S96A NON-MATERIAL AMMENDMENT TO APPLICATION LU/116/21/PL

Further to the consent to the above planning application issued 26 April 2022 please find plans submitted as part of an application seeking a non-material amendment under S96A of the Town and Country Planning Act 1990. We consider the changes, when compared to the consented scheme for 112 dwellings under application LU/116/21/PL, to be minor and not to have any material impact. The specific changes proposed are:

ARUN DISTRICT COUNCIL LU/146/22/NMA

Block Plan

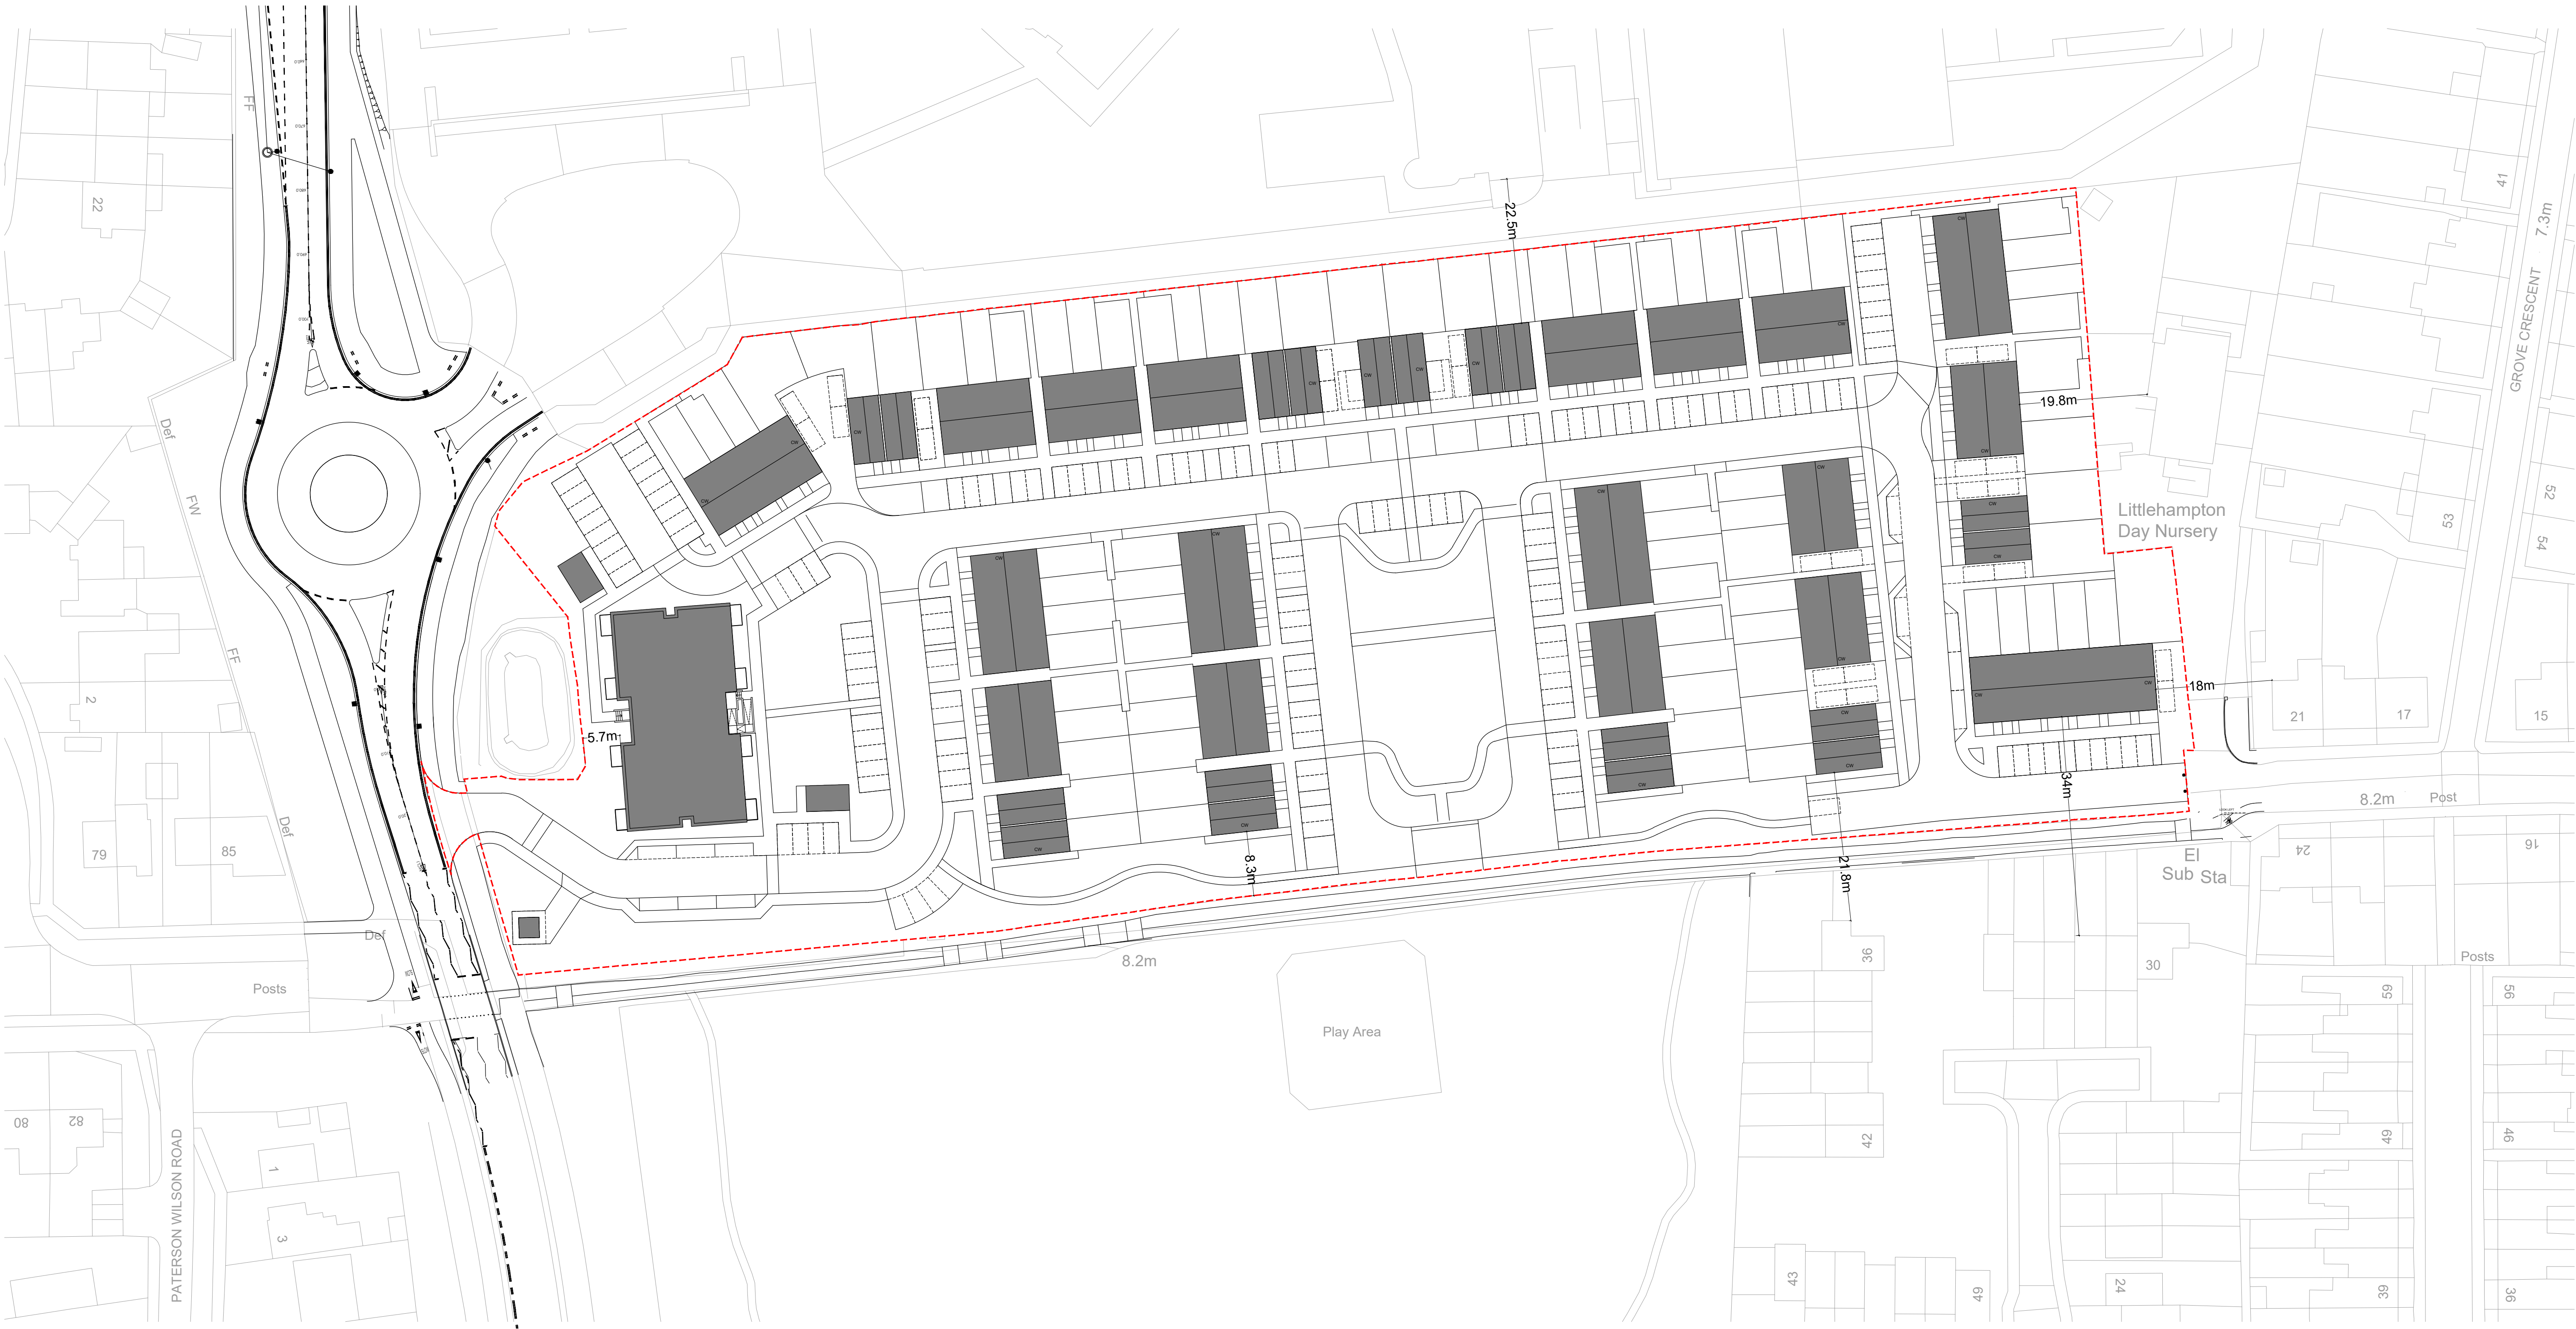
- Illustrative Site Plan& Block Plan: minor updates due to different house types
- Affordable Housing Plan: affordable houses relocated from plots 75 and 77 to plots 93 and 94
- Refuse Collection Plan: updated with slightly amended air-source heatpump locations as shown on the site and block plans.
- House Type Drawings: the house types within the terraces have been amended at the request of BoKlok sales to provide a greater proportion of 3 bedroom end of terrace houses where previously a number of 2 bedroom houses were located. This has resulted in a change to the handing of the front door on the first house at the left of each terrace. The approved housing mix has not been modified in any way.
- Apartment Block Drawings: minor changes to the roof profile
- Street Elevations: changed to reflect the above modifications to the house types and apartment block.
